Your ref: TR010037
Our ref: JEC/JB51570
DD: [REDACTED]
E: [REDACTED]@bidwells.co.uk
Date: 3 February 2022

THE TRUSTEES OF THE CM WATT RESIDUAL TRUST – APPLICATION BY HIGHWAYS ENGLAND (NOW NATIONAL HIGHWAYS) FOR AN ORDER GRANTING DEVELOPMENT CONSENT FOR THE A47-A11 THICKTHORN JUNCTION PROJECT

ENGINEERING DRAWINGS & LONG SECTIONS
REGULATIONS 5(2)(o) & 6(2)(a)
CANTLEY LINK ROAD (CH. 0 TO 955)
SHEET 1 OF 1

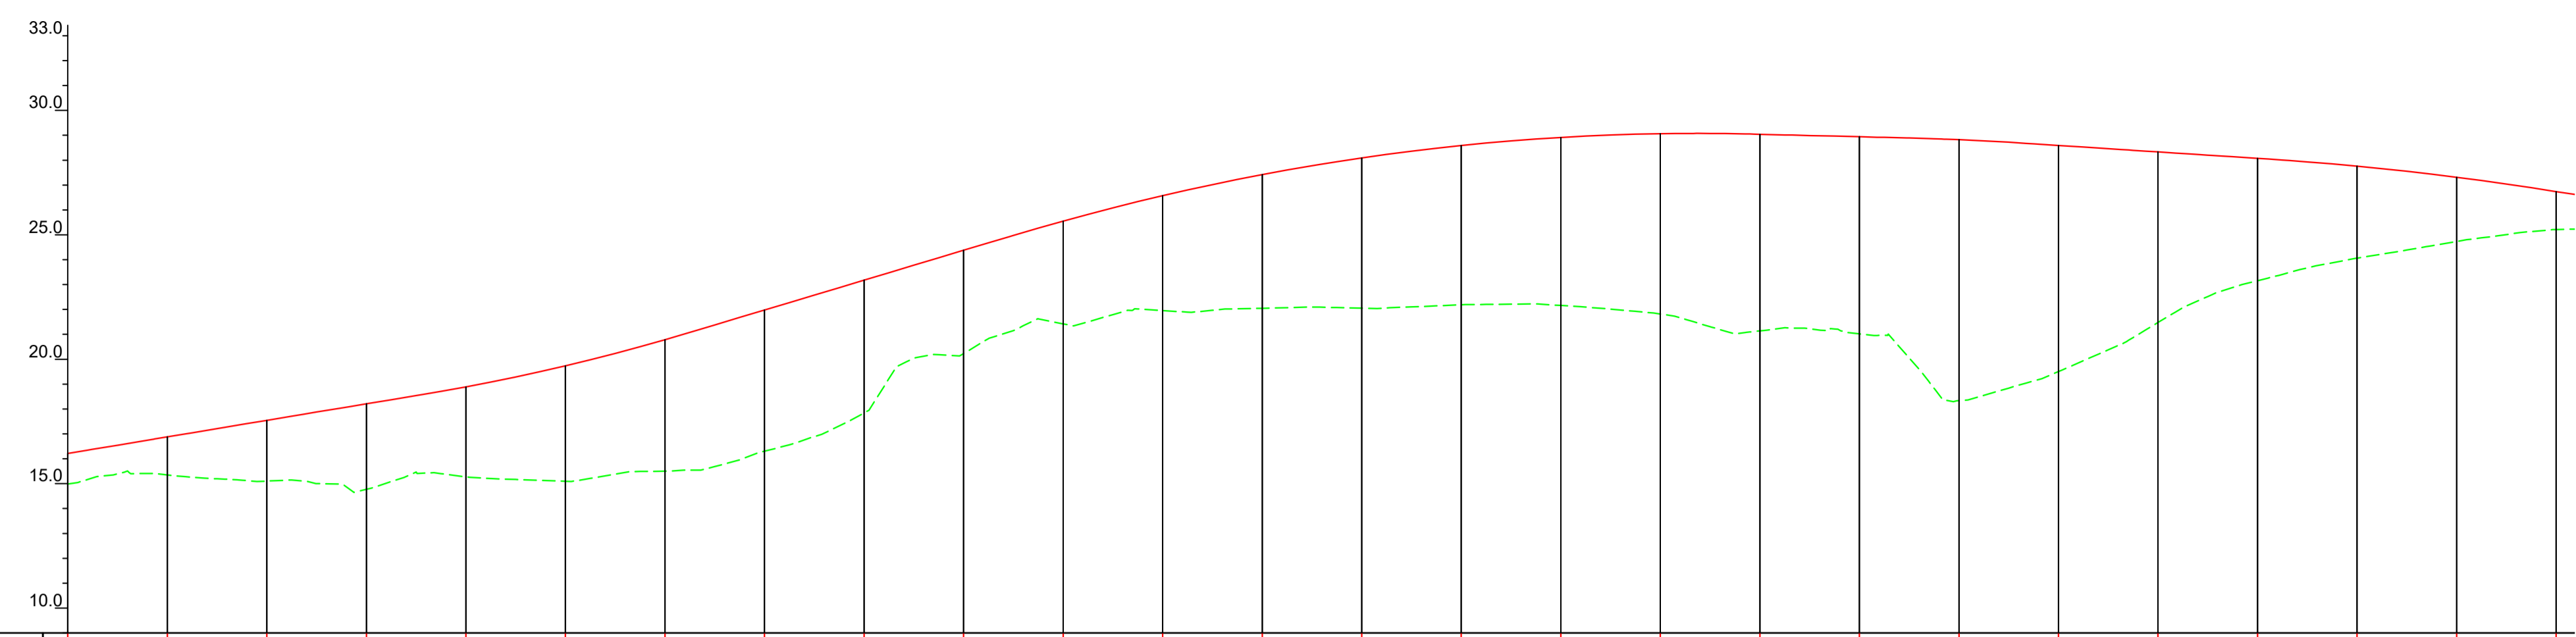
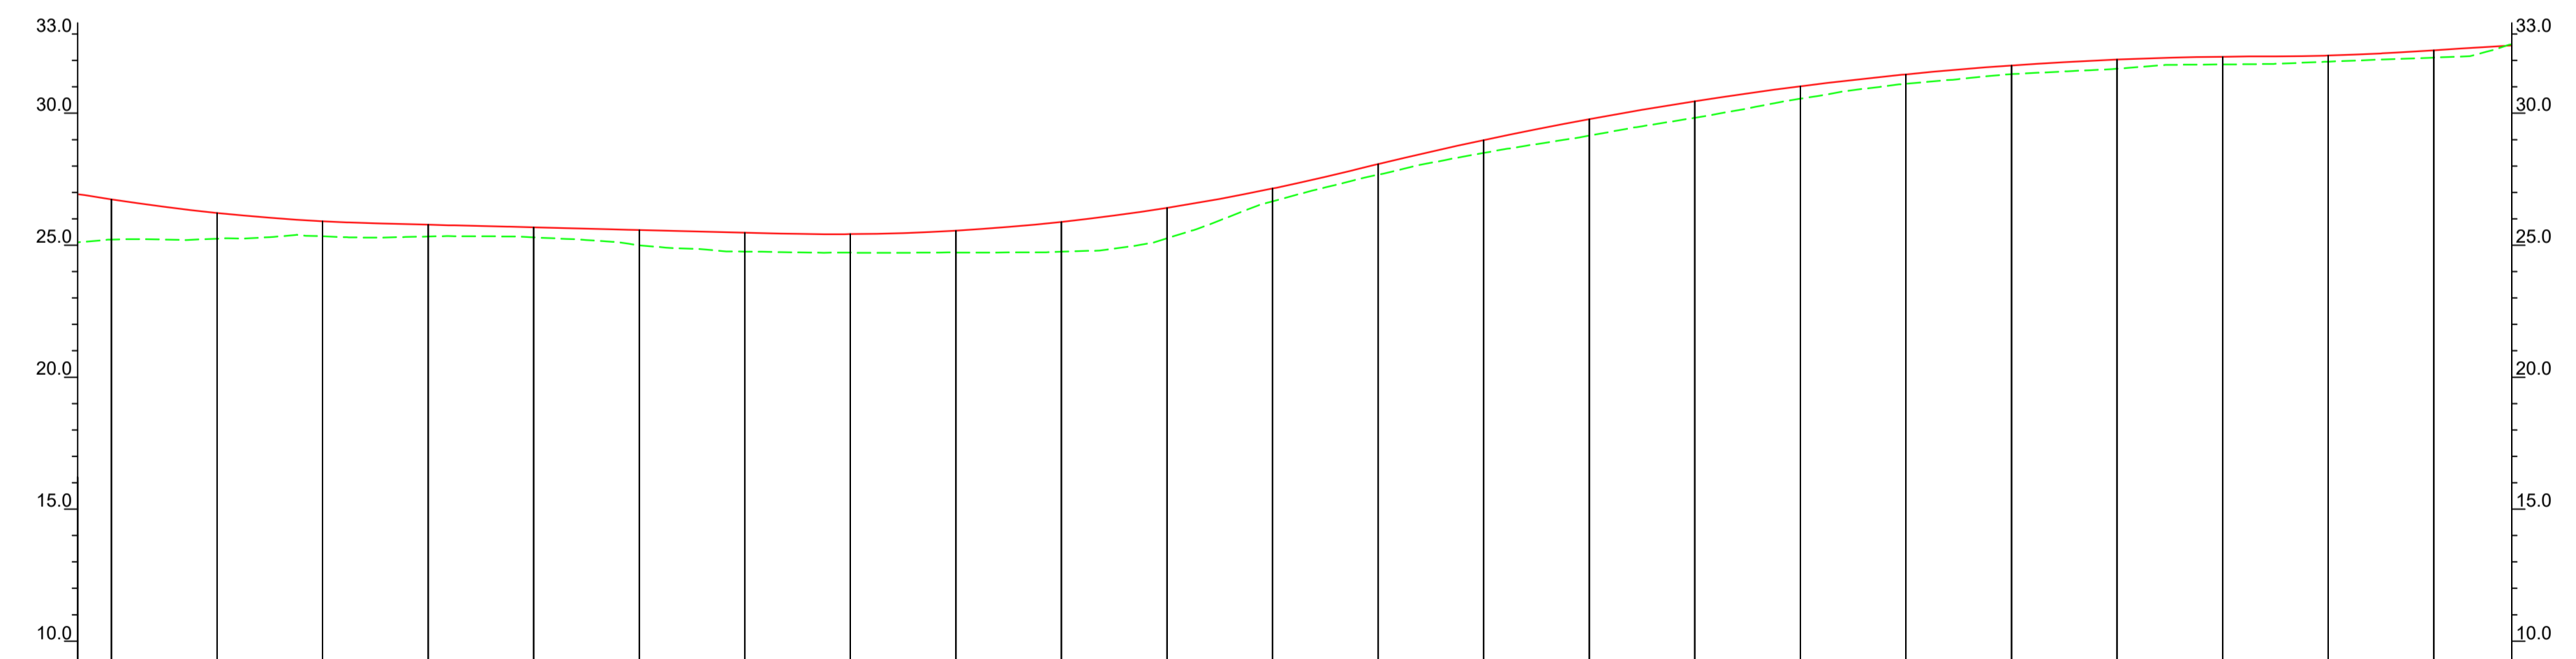
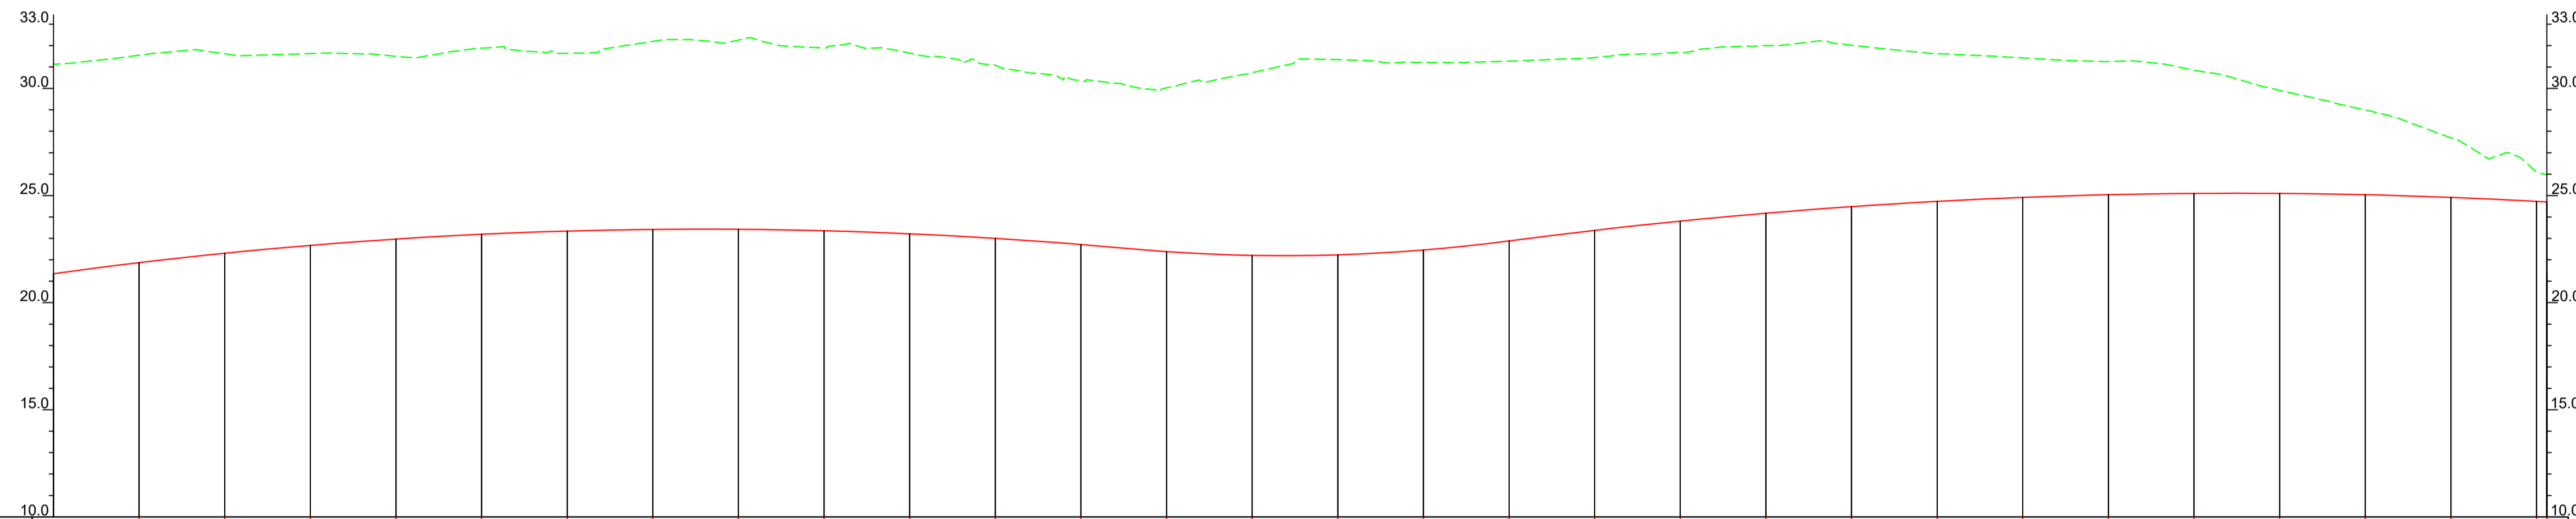
1. We still have serious concerns regarding the form of junction being proposed where the proposed Cantley Lane Link Road shall meet with the B1172 Norwich Road. It is understood Highways England have carried out traffic modelling to inform their design and are satisfied the proposed T-junction will be capable of meeting the demands placed upon it safely but our own daily experience of turning eastward onto the B1172 from the Thickthorn Estate, or turning onto the Estate from the eastward lane of B1172, is this is already a very time consuming and potentially dangerous manoeuvre that will only become more so as the population in this area increases. We therefore respectfully ask that the Planning Inspectorate please looks in detail at the data on which Highways England's decision has been based because it does not fit with my client's lifetime of experience.
